15 December 2023

**Re: SSD-8996 – Mod 1 - Loreto Normanhurst - 91-93 Pennant Hills Road and 6-12 Mount Pleasant Avenue, Normanhurst – Response to latest amendment**

APPENDIX 6
 TREE REMOVAL / RETENTION PLAN
 MASTER PLAN + STAGE 1 WORKS
 LORETO NORMANHURST
 91-93 PENNANT HILLS ROAD, NORMANHURST

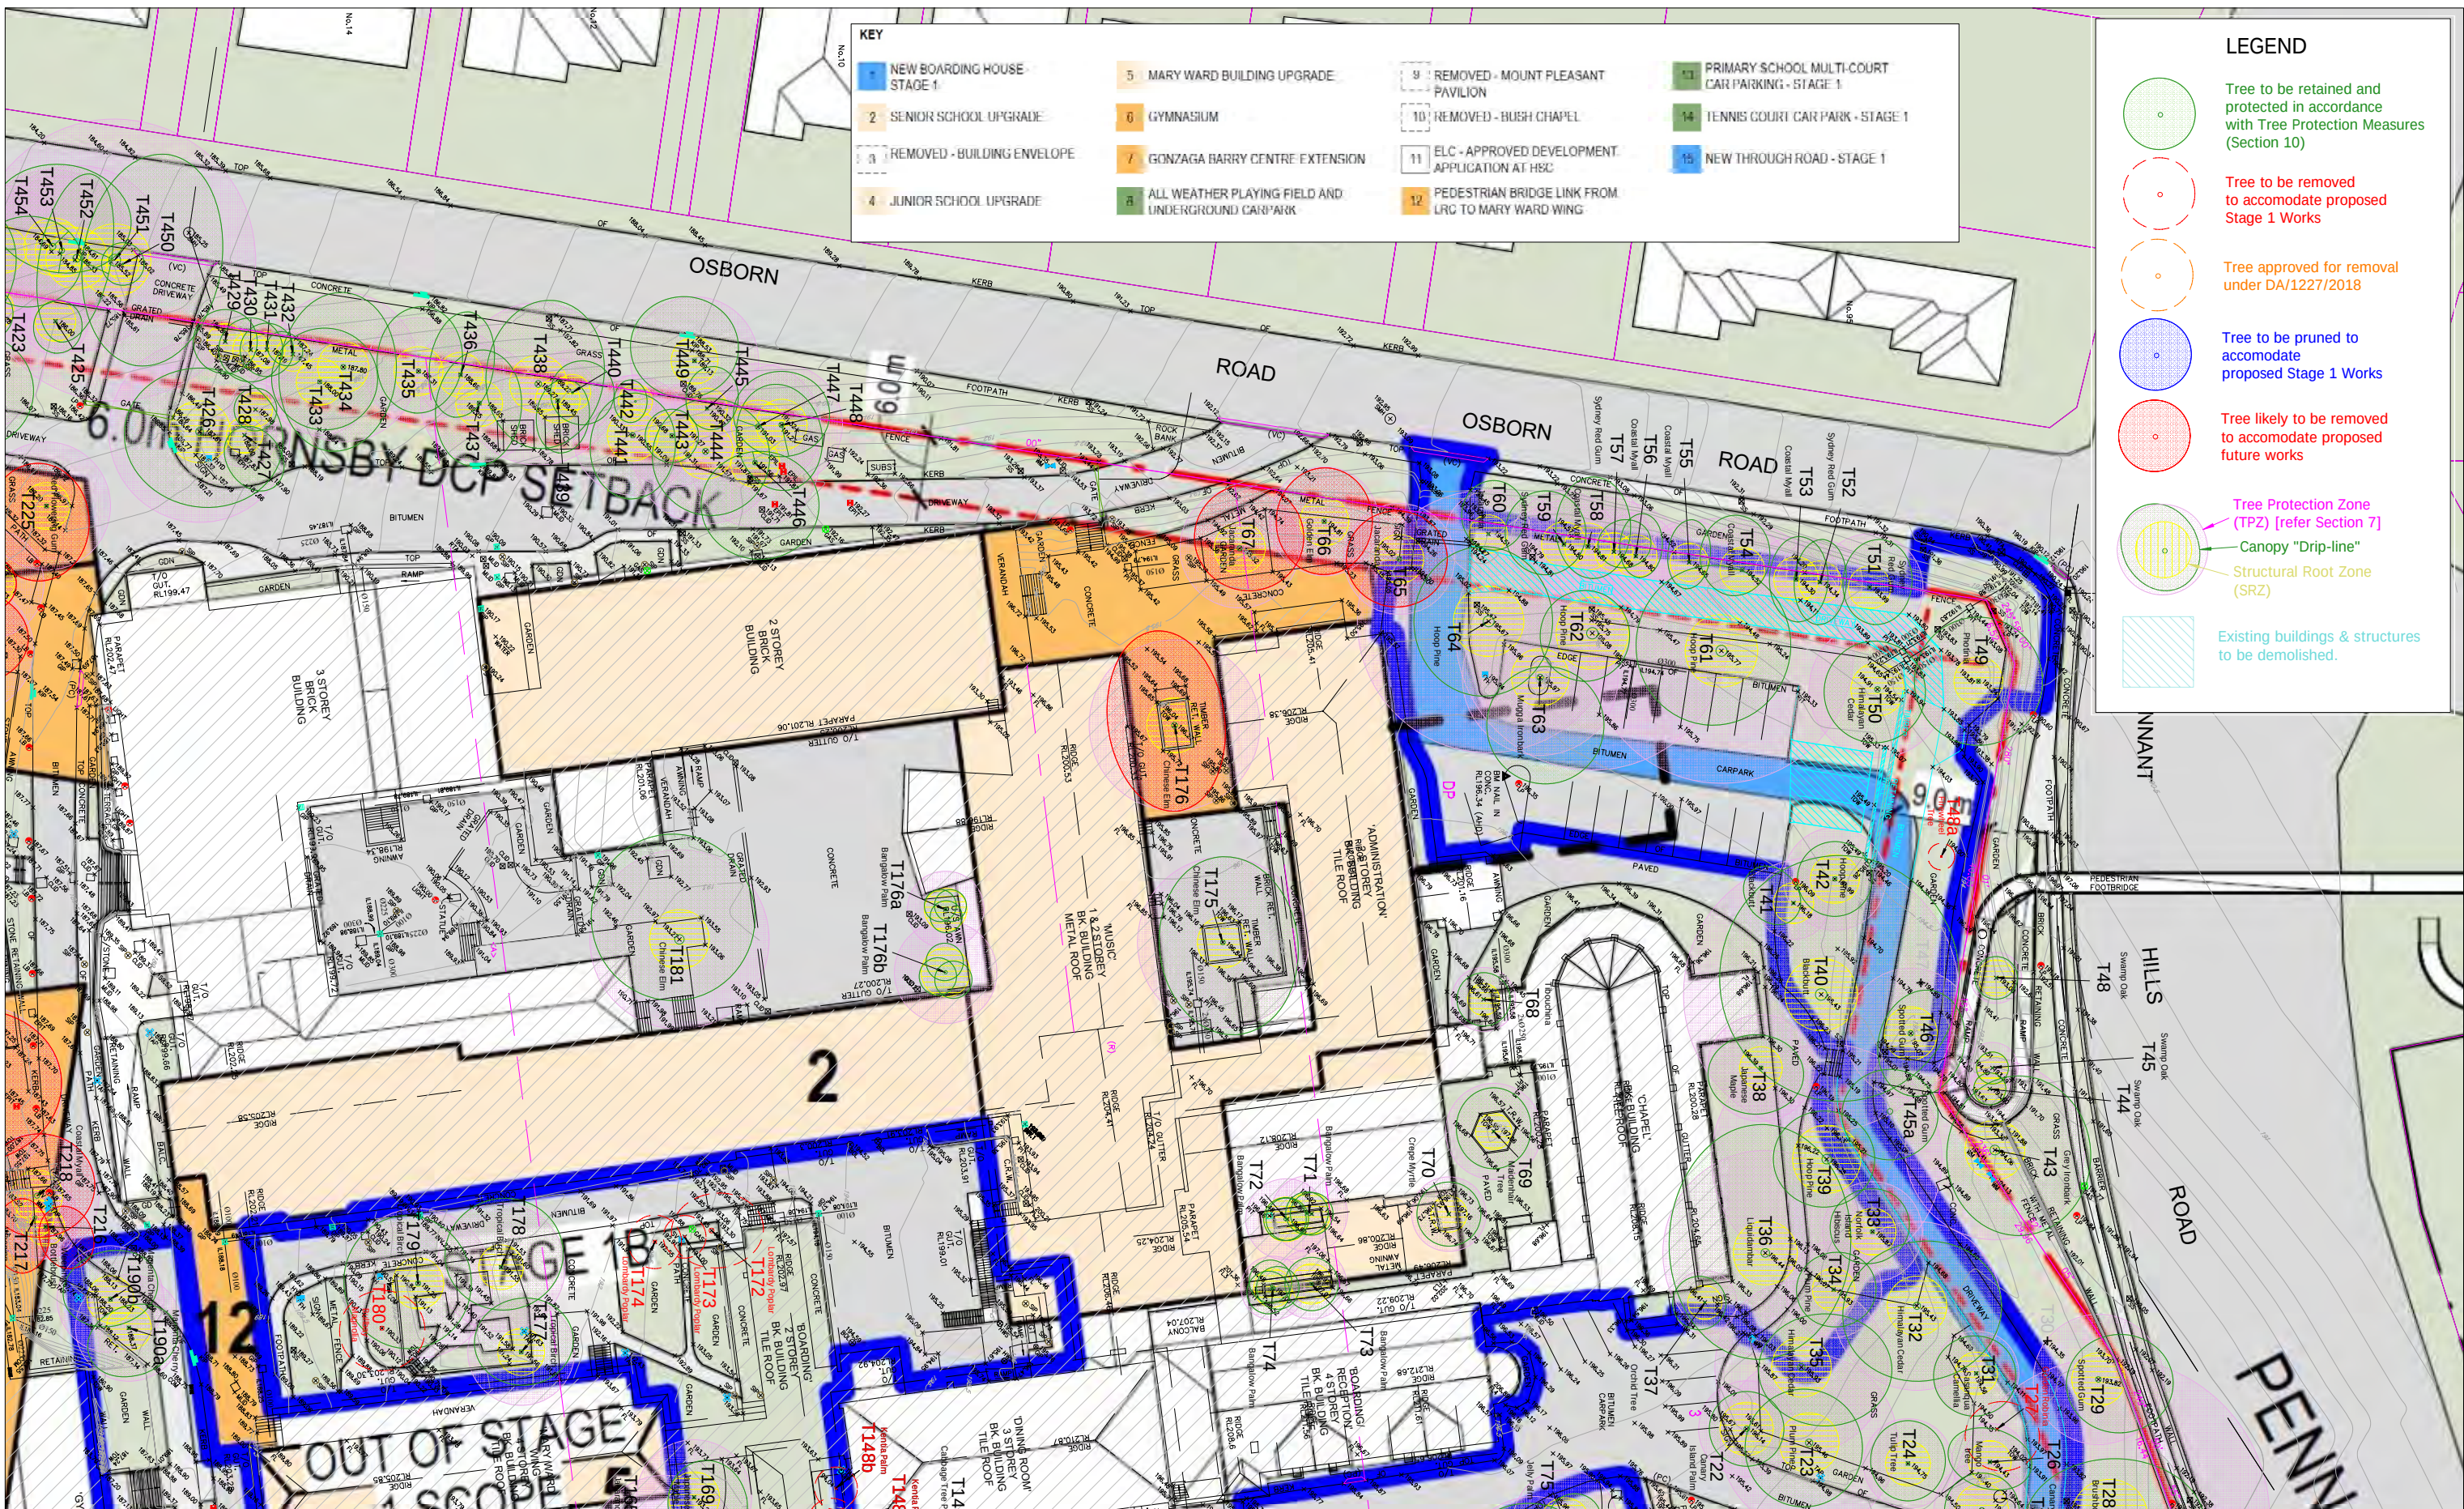
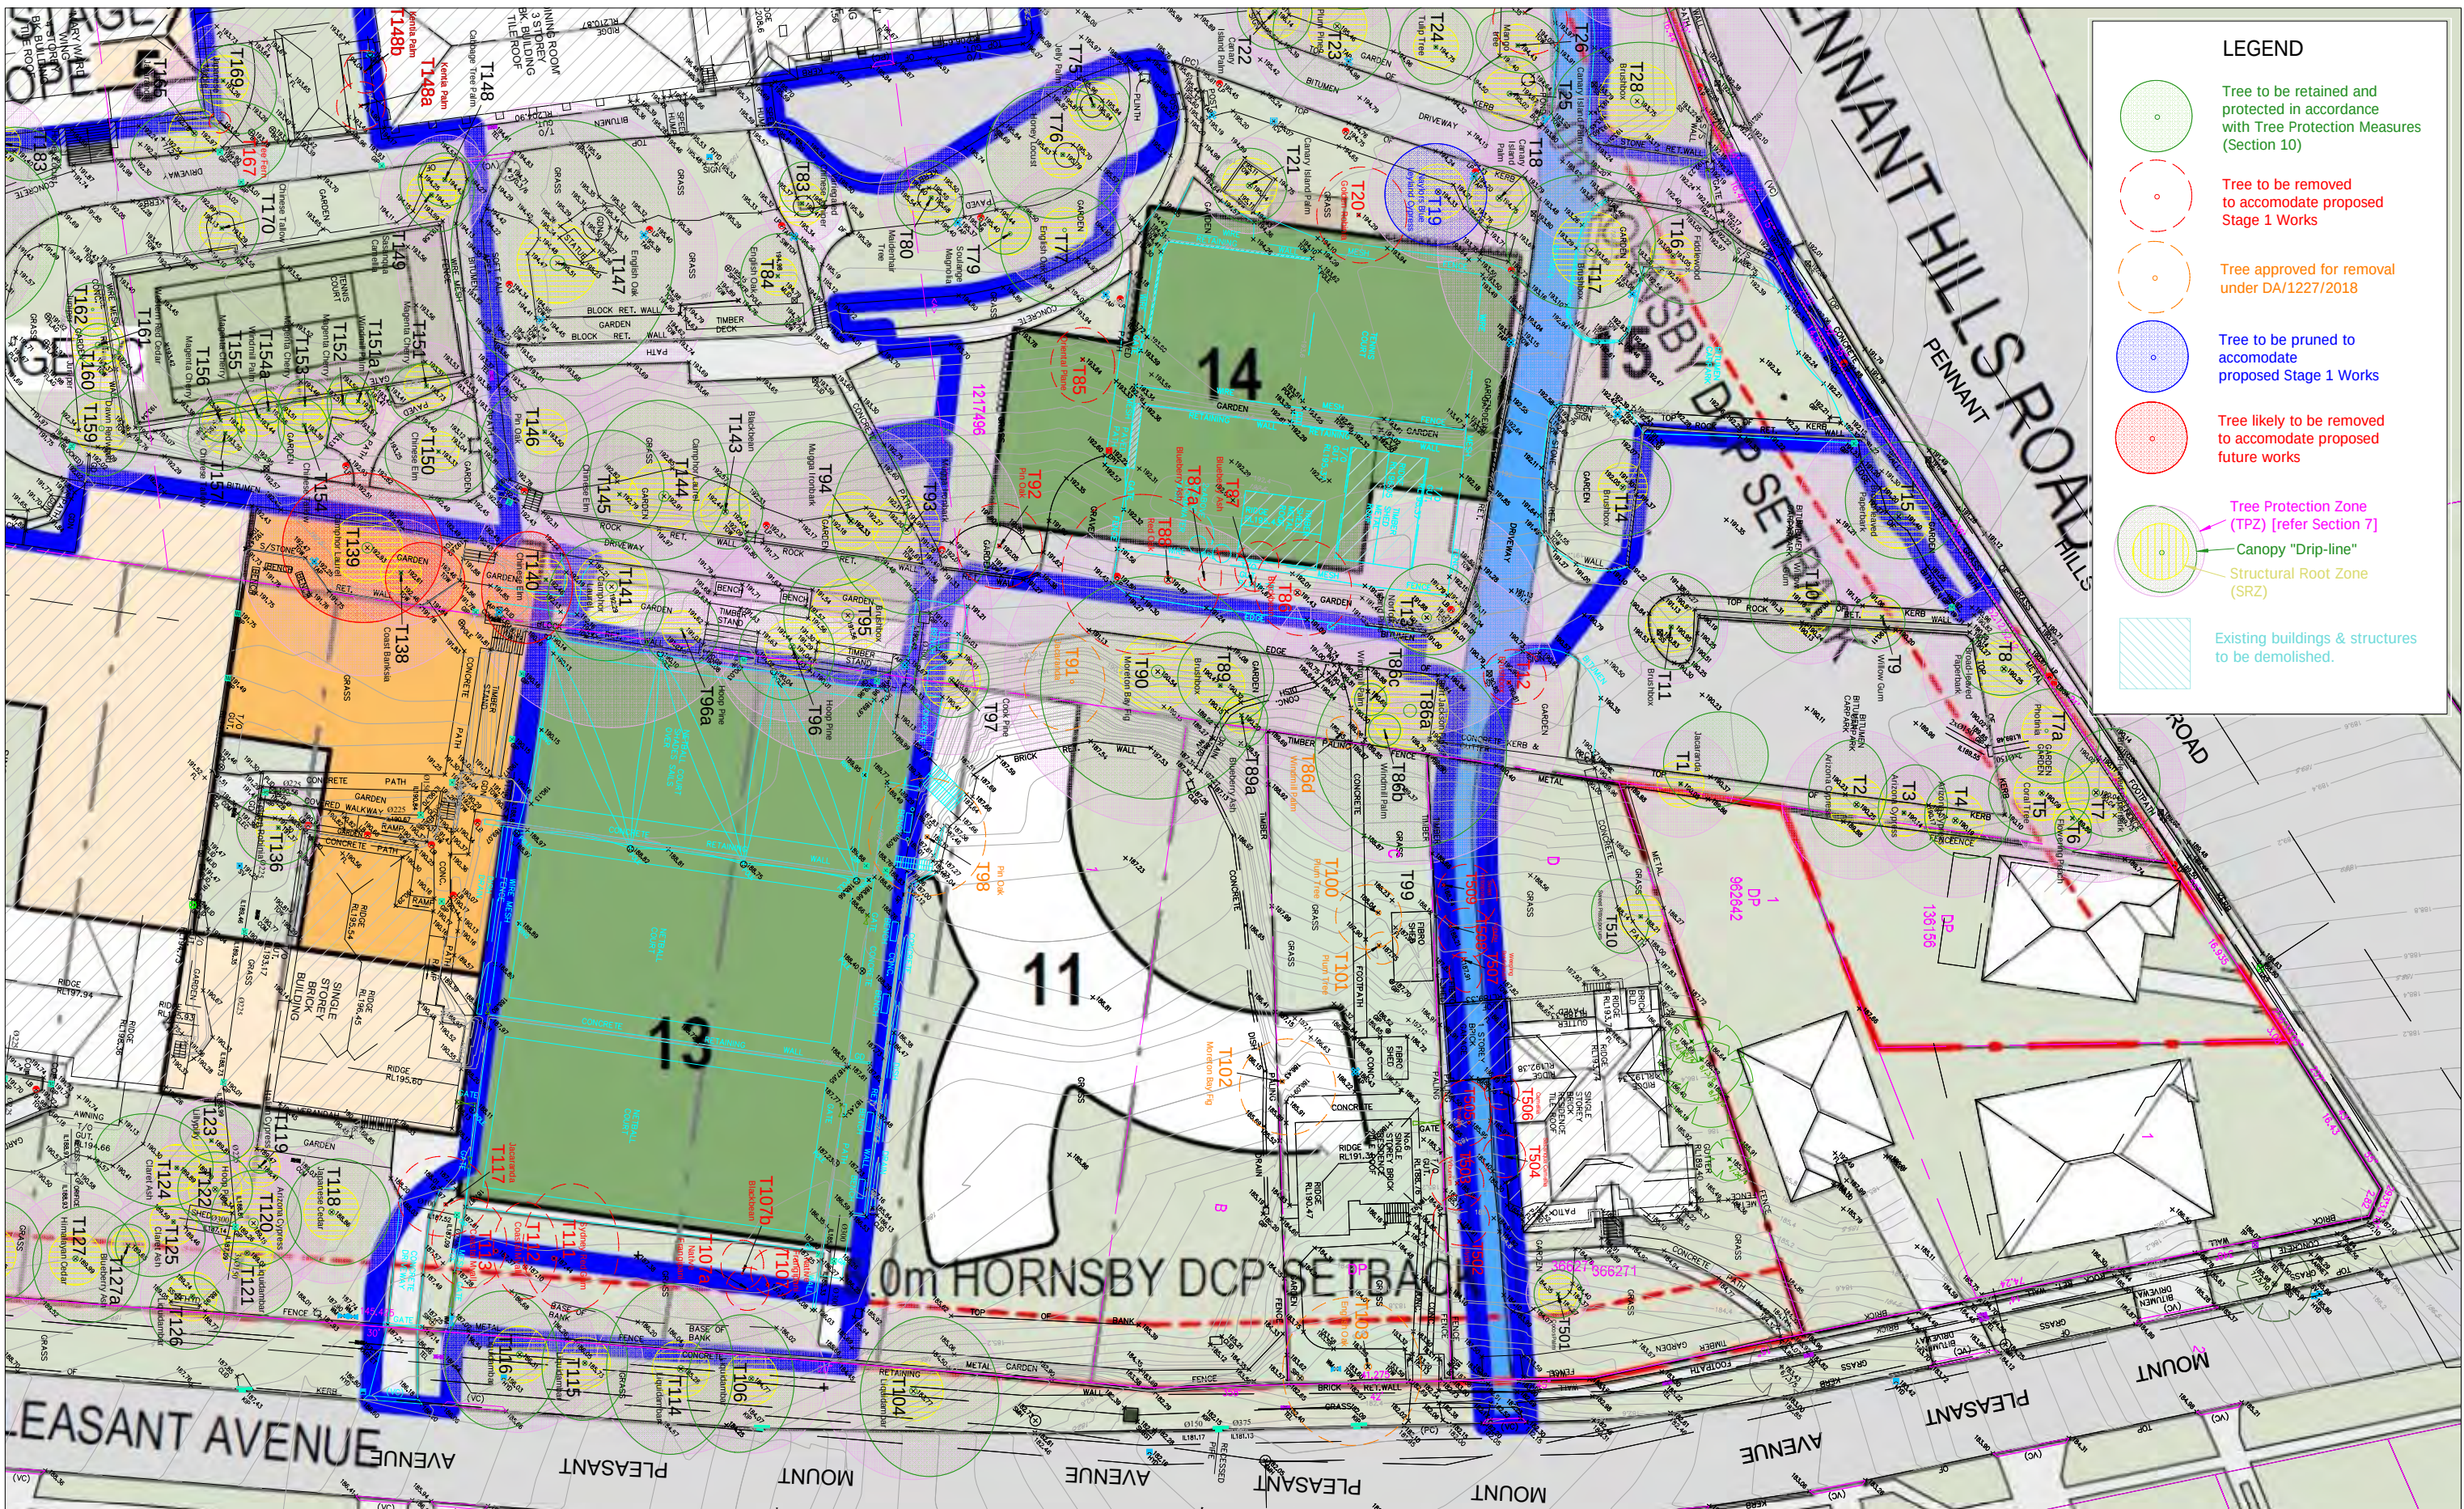
- Numerous trees are plotted for removal to accommodate fill batter for a pedestrian pathway and driveway ramp. It is suggested the Department review retaining more of these trees by utilising sensitive tree construction techniques and utilising different construction materials/techniques such as pier and beam instead of fill batter.
